Application No: A/207/21/PL
Site Address: Land off Arundel Road Angmering BN16 4ET
Description of works: Variation of condition following grant of A/122/19/OUT relating to Conditions Nos 4 - approved plans and 16 - vehicular access.

Thank you for your internet representation made on 3rd November 2021 which has been recorded as an objection with the comments as follows:

Title:
**Commercial Access - General Arrangement
1no Footway, North Side**

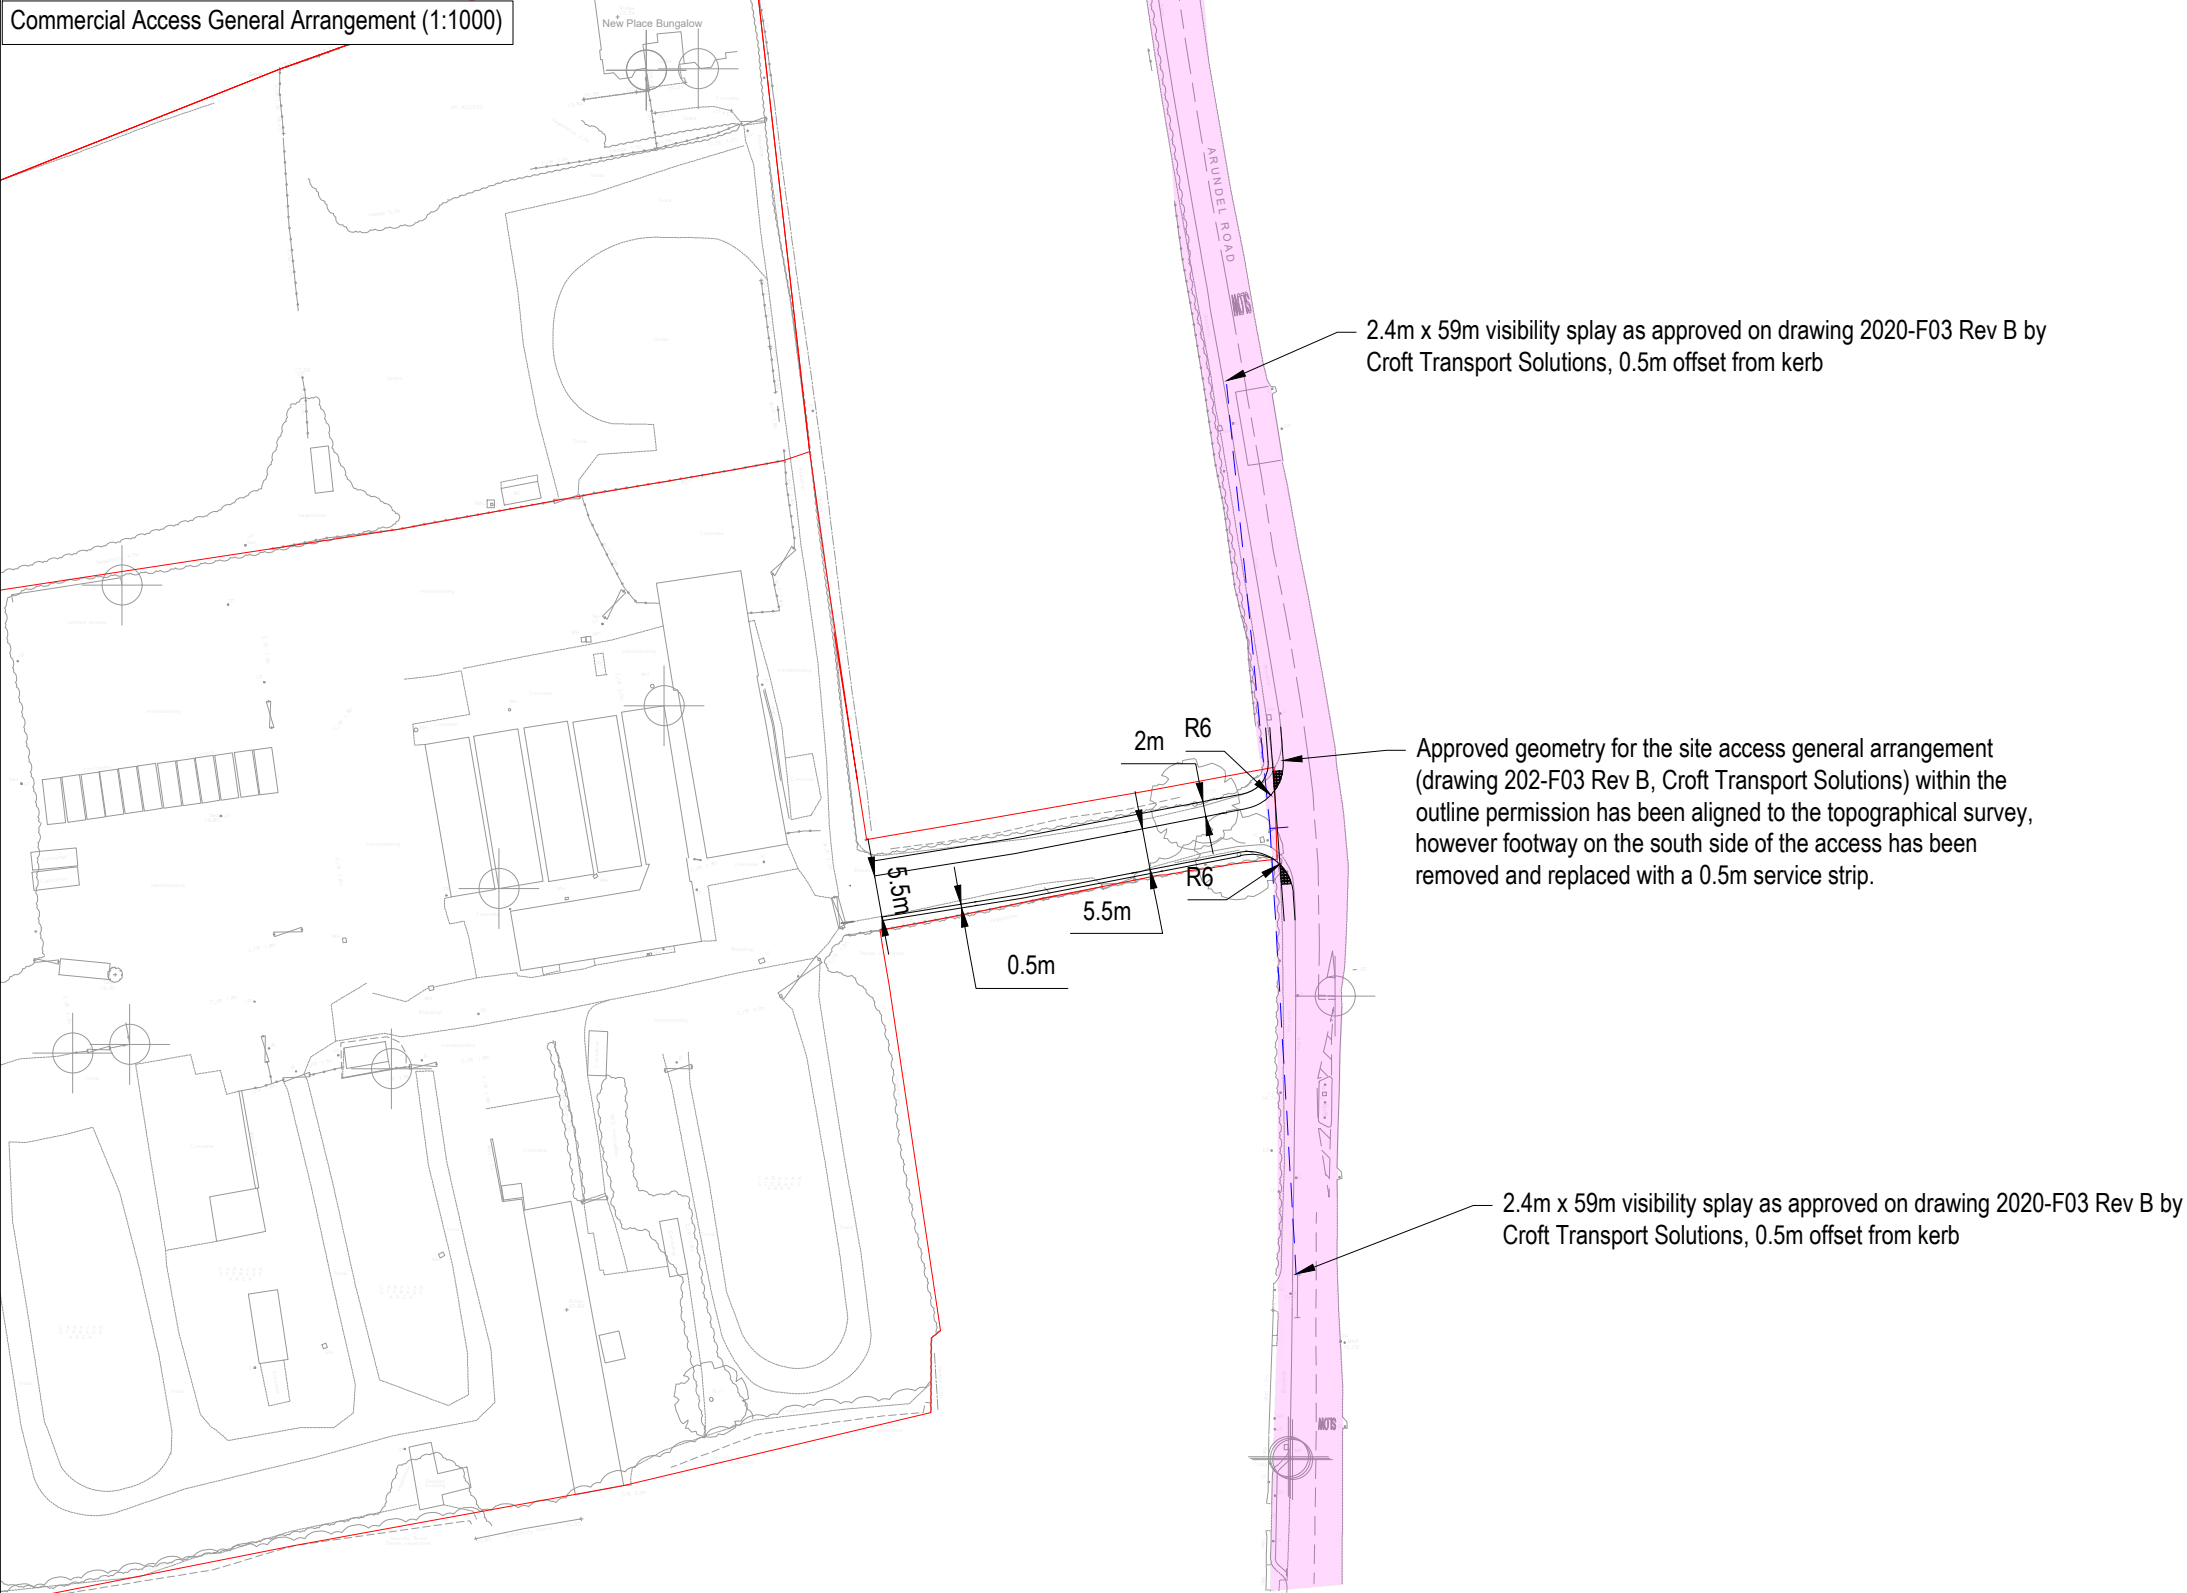
Objection to the amendment proposed to the planning consent centring on the elimination of a footpath on the South side of the development linking to Arundel Road.

The proposal conflicts with Arun Local Plan, Policy T SP1 Clauses f) ii & iii, and Angmering Neighbourhood Plan, Policy TM1, in relation to prioritising the needs and safety of pedestrians. Elimination of the footway will both discourage pedestrian traffics as well as creating a hazard, particularly for disabled persons and children forced to cross an uncontrolled 'bellmouth' to utilise the footpath opposite, for whatever reason.

In the interests of safety and prompting movement by foot now and in the future, this element of the proposal, as presented, should be refused
